# ELLCOTT SAND AND GRAVEL LLC - SITE DEVELOPMENT PLAN

## STAGE 1 OF 6 - EA#1881

EL PASO COUNTY DEVELOPMENT PLAN  
SITE DEVELOPMENT  
FOR  
SCHUBERT RANCH SAND RESOURCE  
ELLCOTT, COLORADO

FILE NAME:	1/6/2023
ESG-DR SITE PLAN	
SCALE:	AS NOTED
DRAWN BY:	EM/MS
CHECKED BY:	BH
ADD PCD FILE #	PPR-23-04

STAGE I OF 6 - DRAINAGE PLAN

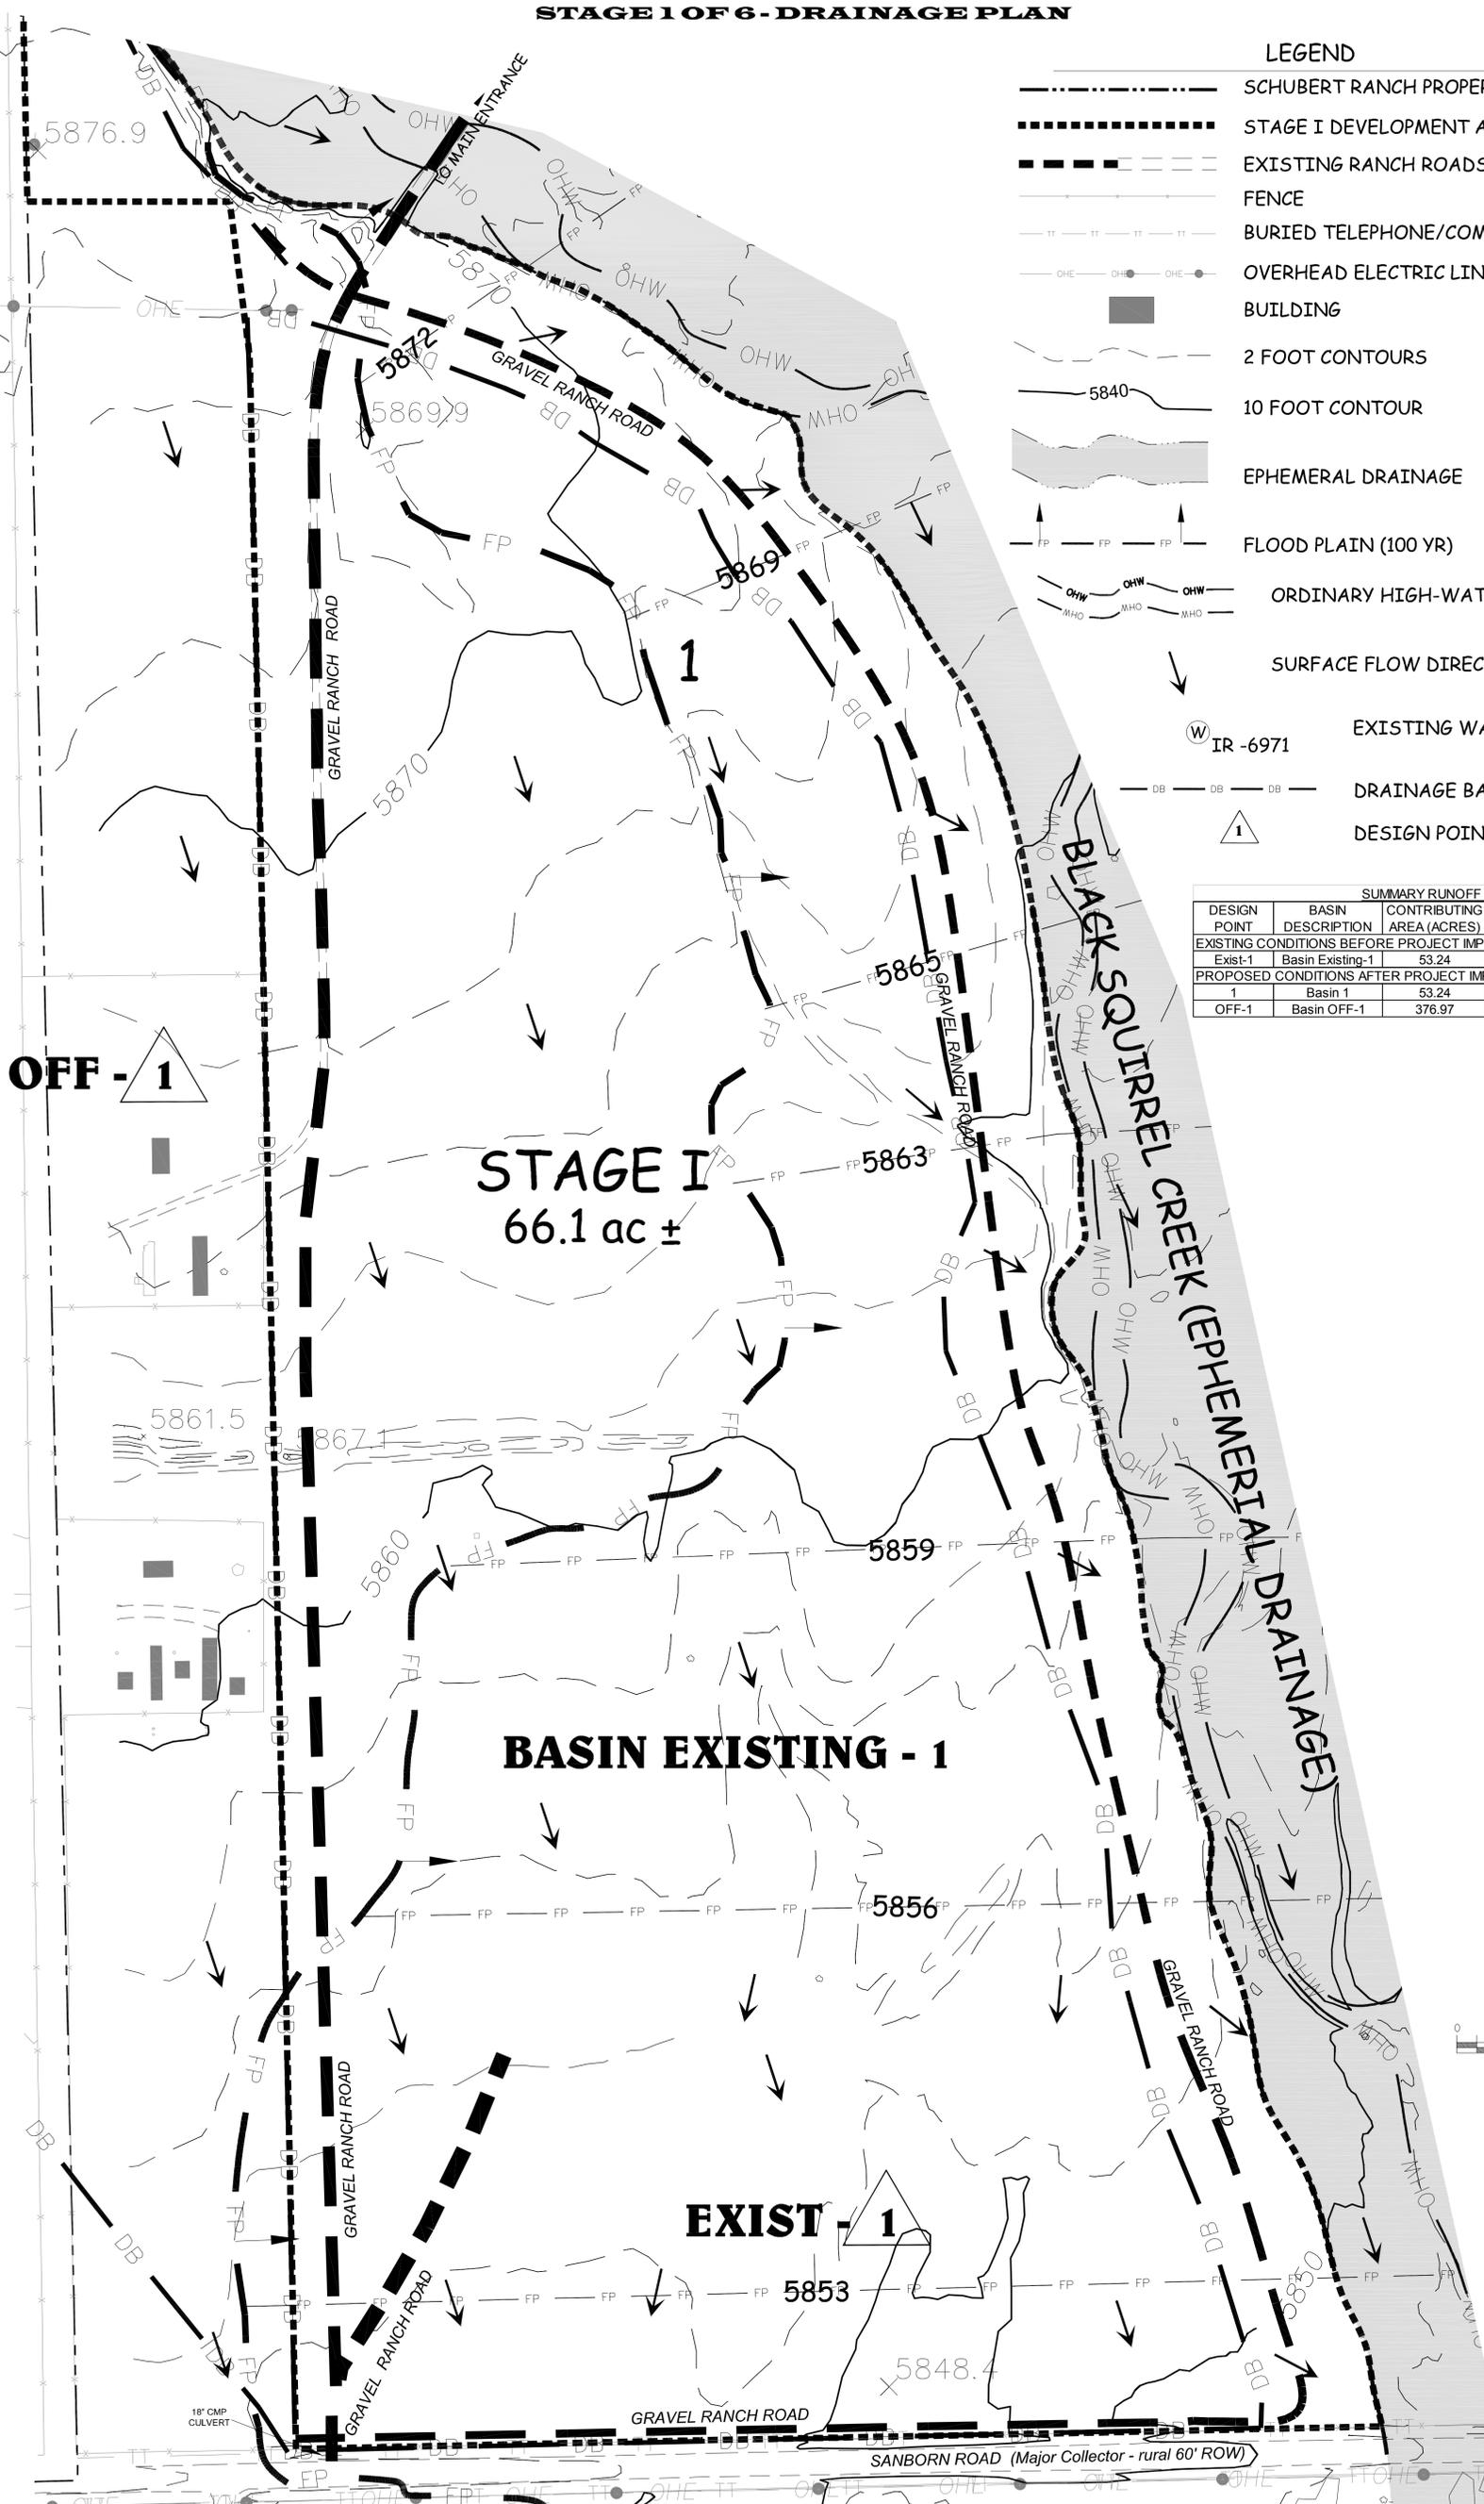
Provide a scale for the SDP drawing. Distances cannot be verified

Correct property line to match legend. make it bold as shown on the legend

Are these residential properties/homes with a driveway access? Provide details and label homes

Provide entrance gate location detail with setback per LDC 6.3.3 Gate Location and Dimensions. Gates shall be located a minimum of 30 feet from the public right-of-way and shall not open outward. The opening provided through a gate shall be 2 feet wider than the traveled way.

Show and label this additional driveway access. Access spacing not met per ECM 2.4.1. Provide deviation or close driveway access

The proposed access differs from the previously proposed access and deviation request submitted. Please submit a revised deviation request for the proposed access. Be sure to address the spacing with existing access to the west.

When Sanborn Road is paved in future per 2016 MTC the driveway entrance will be required to be paved 50ft inward.

label as Major Collector-rural 60ft ROW

Additional setback and buffer from Sanborn and roadside ditches will be required from the mining limits. Sanborn road planned for improvements per 2016 MTC as a paved major collector with a 90ft ROW. Adjust Mining limit demarcation line further back to match GEC Plan which denotes undisturbed area.

~150ft setback buffer. Correct SDP to coincide with GEC Plan. Correct mining ToS limit line

If the haul route is adjusted then map will need to be corrected to show Baggett Rd.
